## **Phase 2 – Catalyst, Bicester** **Technical Note – LLFA / CDC Drainage Response**

This technical note has been produced as an addendum to Application No: 22/03677/DISC relating to discharge of Condition 40 (SW Drainage). This condition has been partially discharged for Phase 1 which is now complete. Phase 2 (Units 5-9) is the next and final phase of development for this application. Please find below Bailey Johnson Hayes responses to consultee comments received to date.

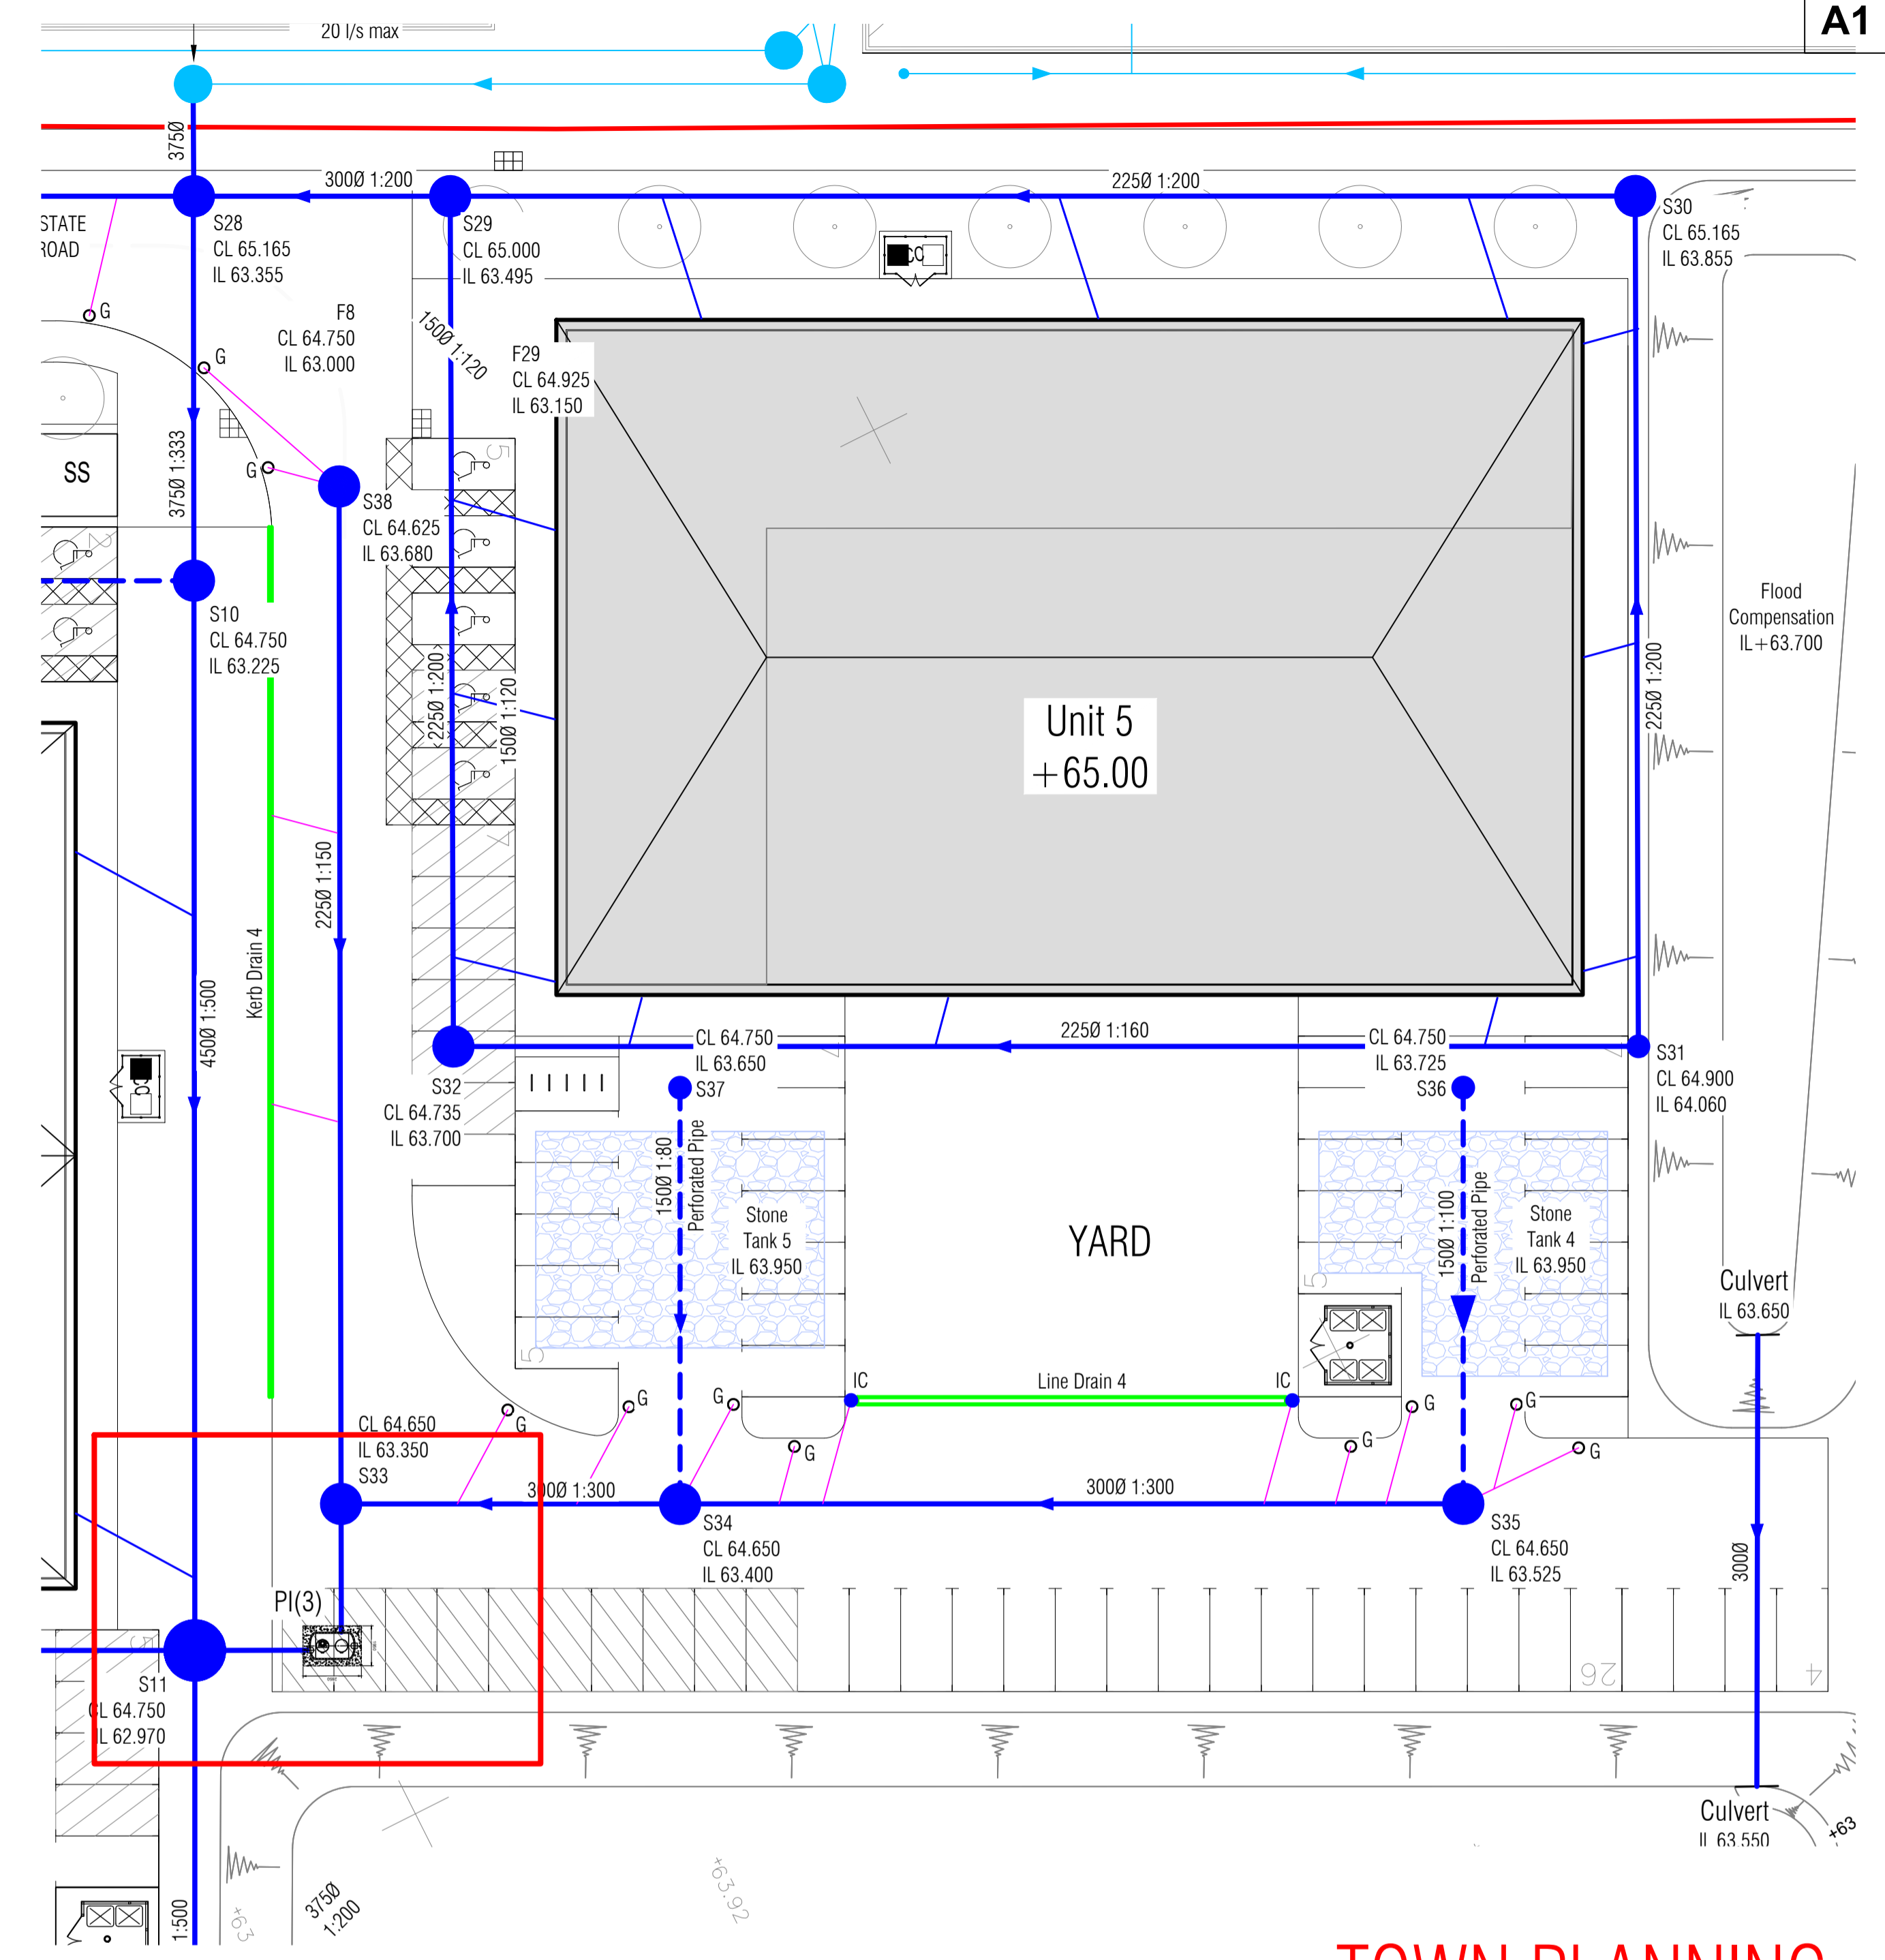
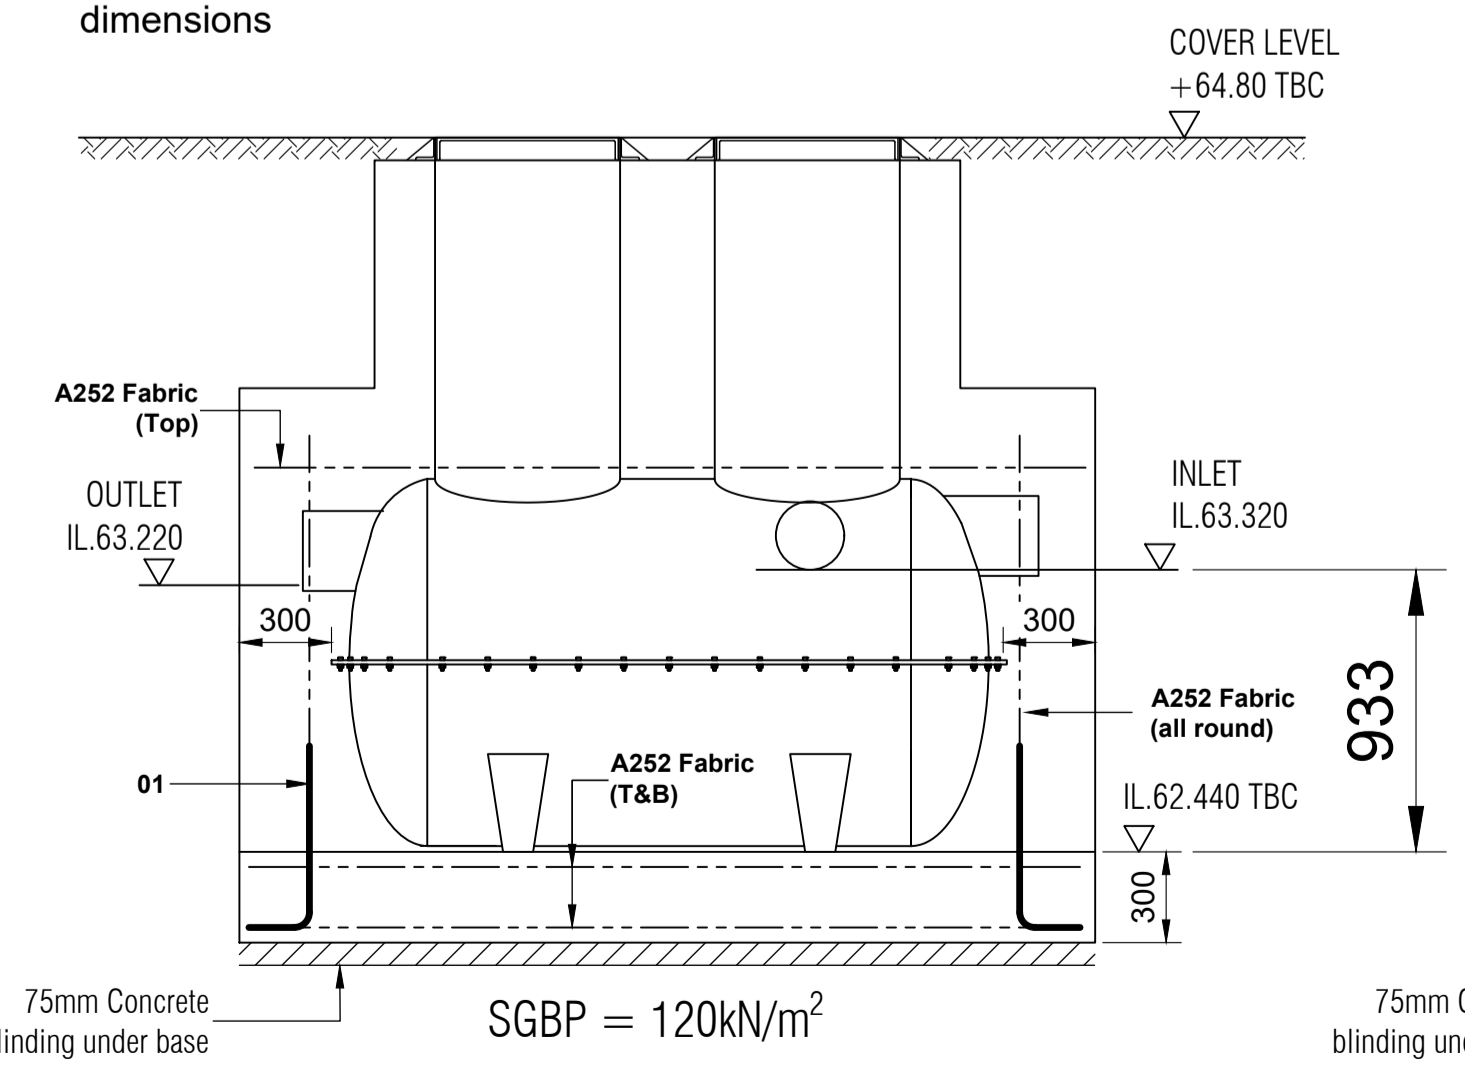
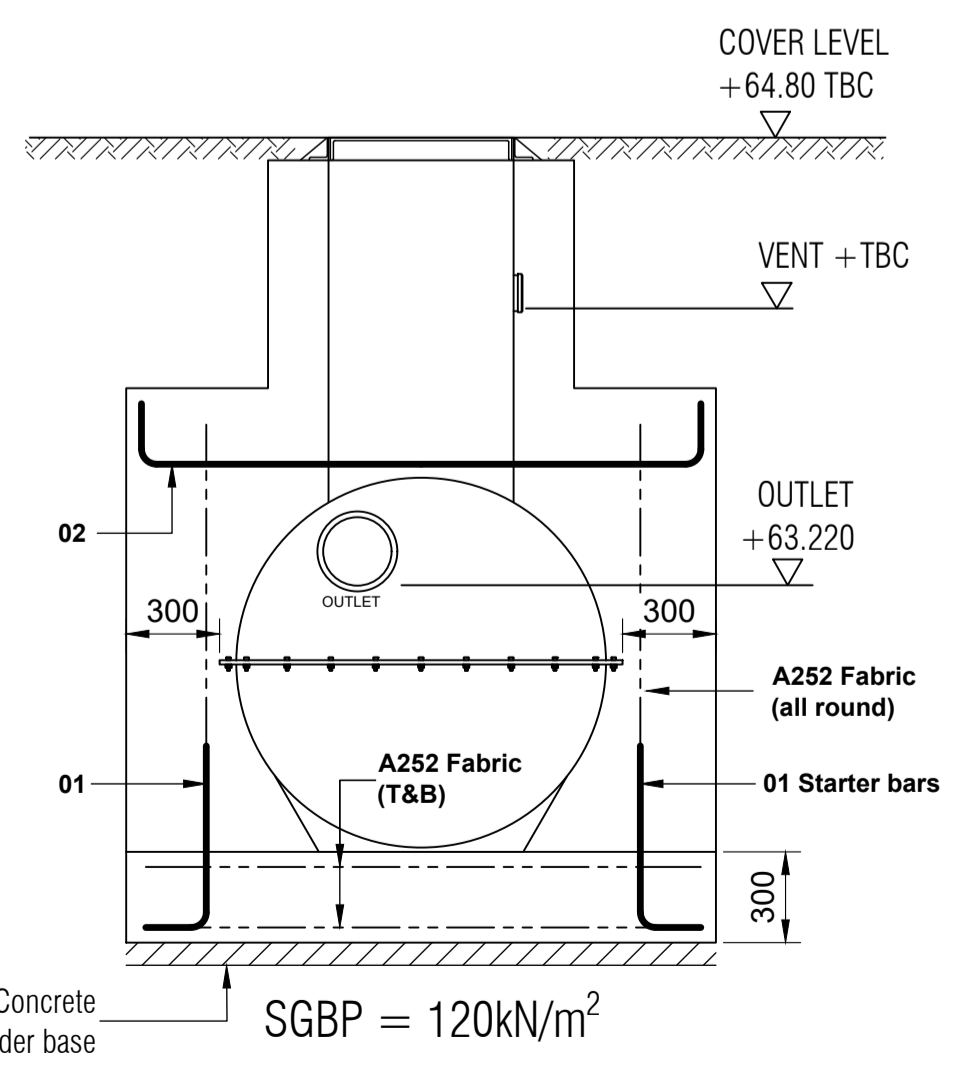
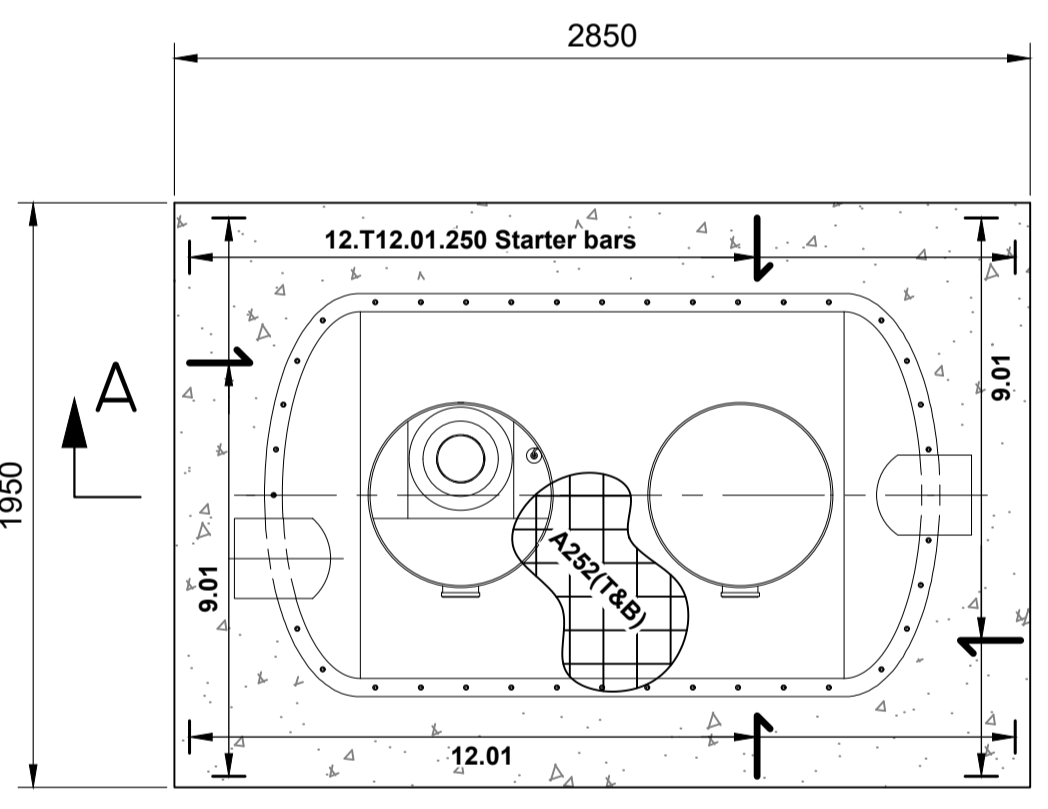
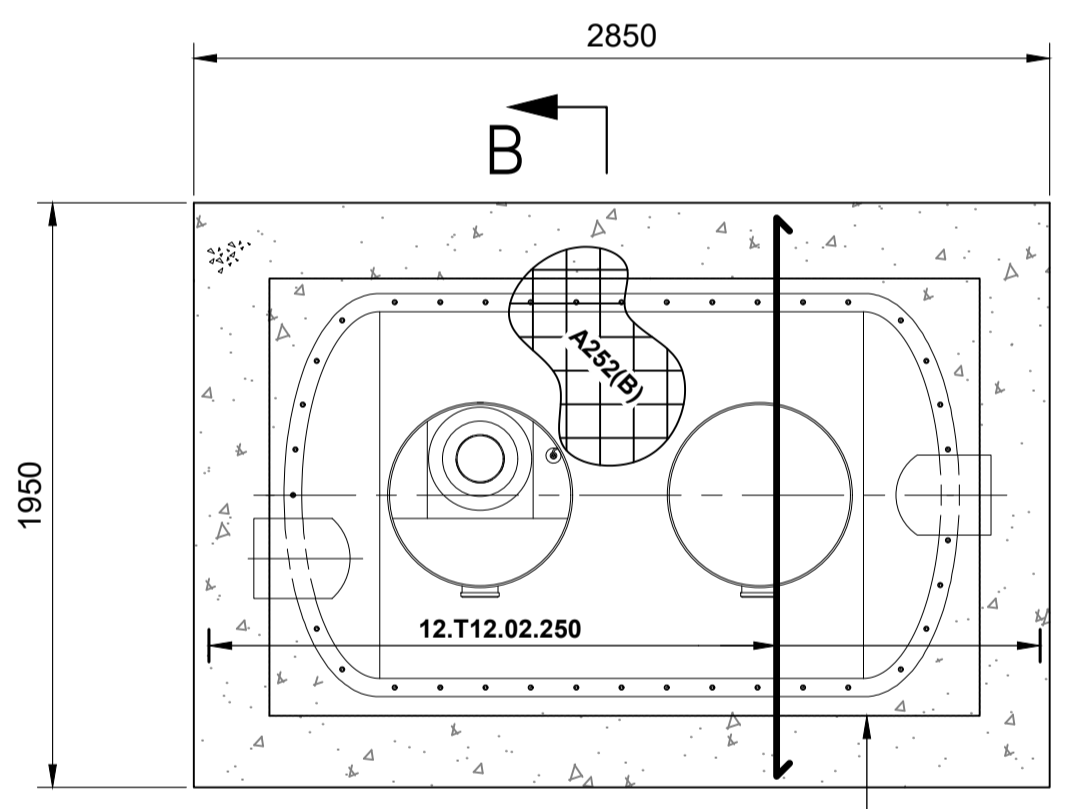
2. Provide SuDS construction details drawings.

New Drawings No. S1358-PH2-17A, 18, 19, 20, 21, 22 & S1358-PH1-23 are now submitted to provide full details of the Attenuation Basin 2, Petrol Interceptors 3-5, Permeable Paving, Hydro-brake outlet manhole, headwalls, culverts and ditches.
